From: Simon Davis
Sent: 10 September 2021 13:51
To: 'Julian Evans' [REDACTED]
Cc: Anita Gardner <Anita.Gardner@arun.gov.uk>
Subject: RE: P/111/21/RES - Sefter Road - Planning progress

From: Julian Evans [REDACTED]
Sent: 10 September 2021 11:57
To: Anita Gardner <Anita.Gardner@arun.gov.uk>
Cc: Simon Davis <Simon.Davis@arun.gov.uk>
Subject: P/111/21/RES - Sefter Road - Planning progress

Status Planning		
Scale 1:500@A3	Drawn By JE	Date June 21
Project No. 20156	Drawing No. P003	Revision B

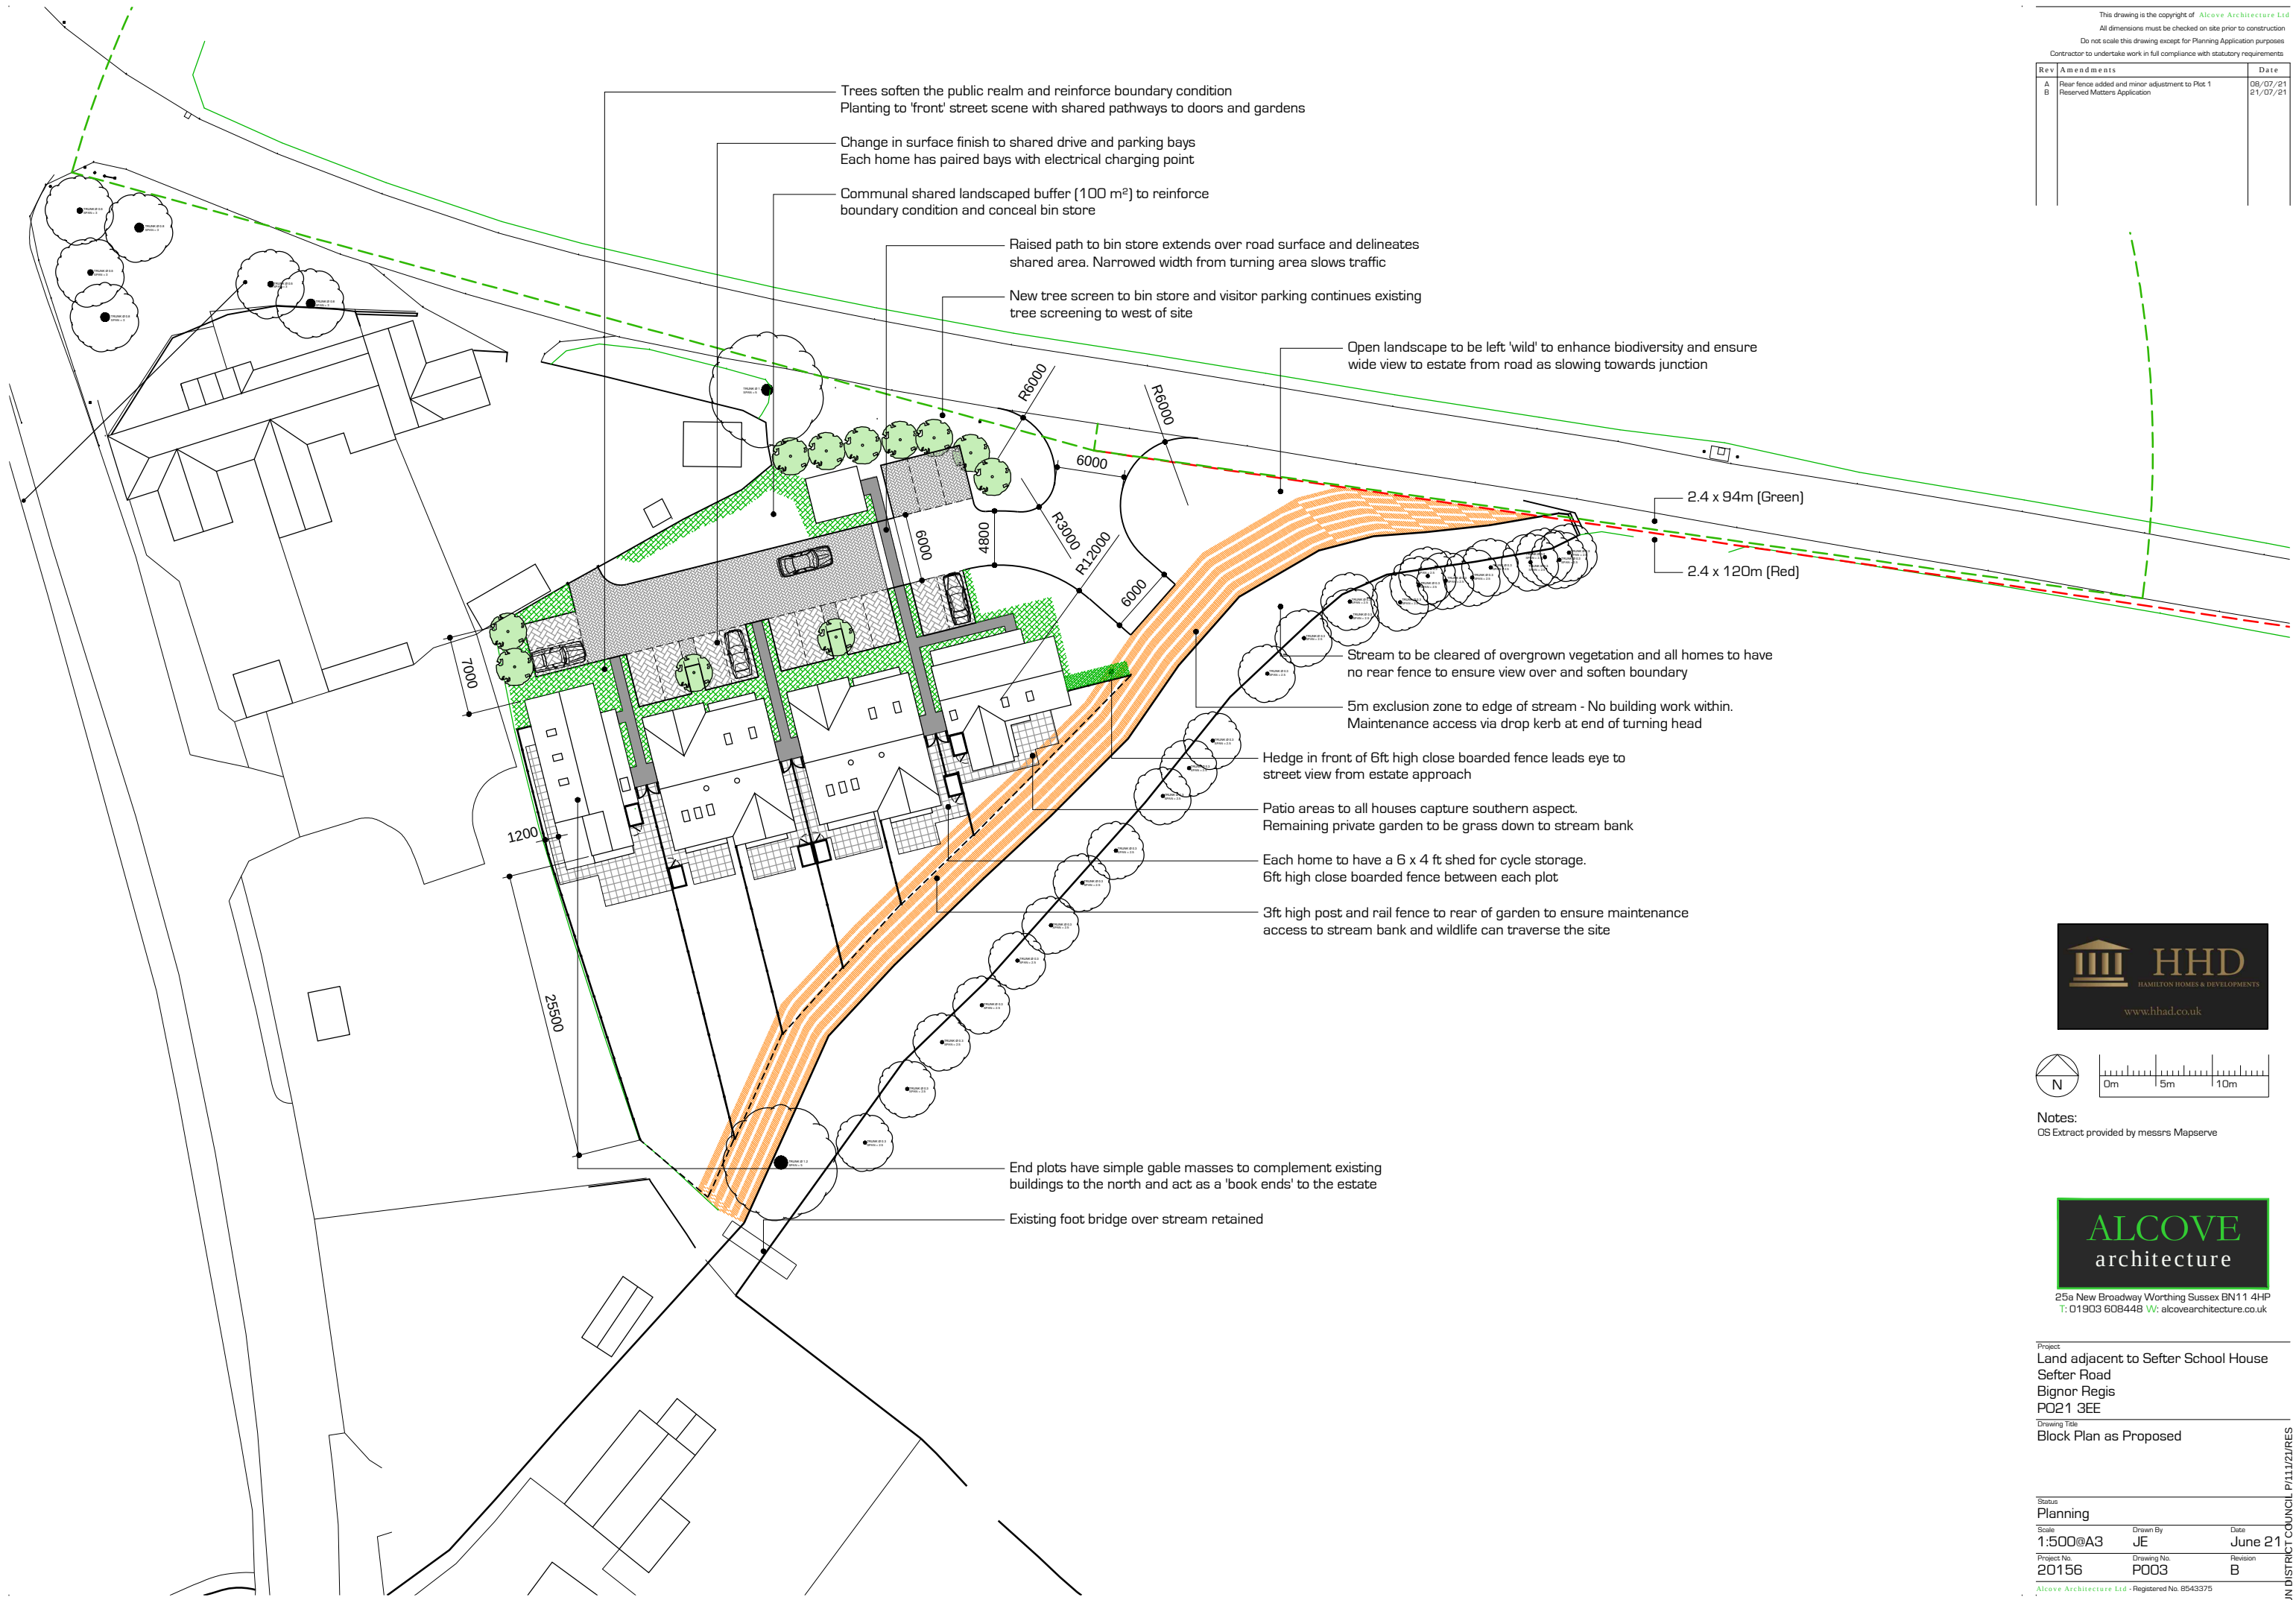
I have calculated the parking requirements per the APS as 3 per dwelling (18) plus 1 visitor so 19. On that basis, you are short by 4 spaces. Given the site location (limited accessibility by means other than the car), it is felt that parking should meet the requirements. I'll leave this with you to consider.

We also note on the website that WSCC Highways are requesting additional visitor spaces which appear beyond the number identified on the original Outline Approval and possibly beyond the number that could be calculated using Arun Parking Standards (APS) Jan 20 or WSCC Parking Standards Sep 20. To clarify, each dwelling has 6 habitable rooms which equates to 15no total using APS as designed (over the 13no required by WSCC). However, if using the 4 bed definition, this equates to 22no total using APS or 17no total using WSCC.
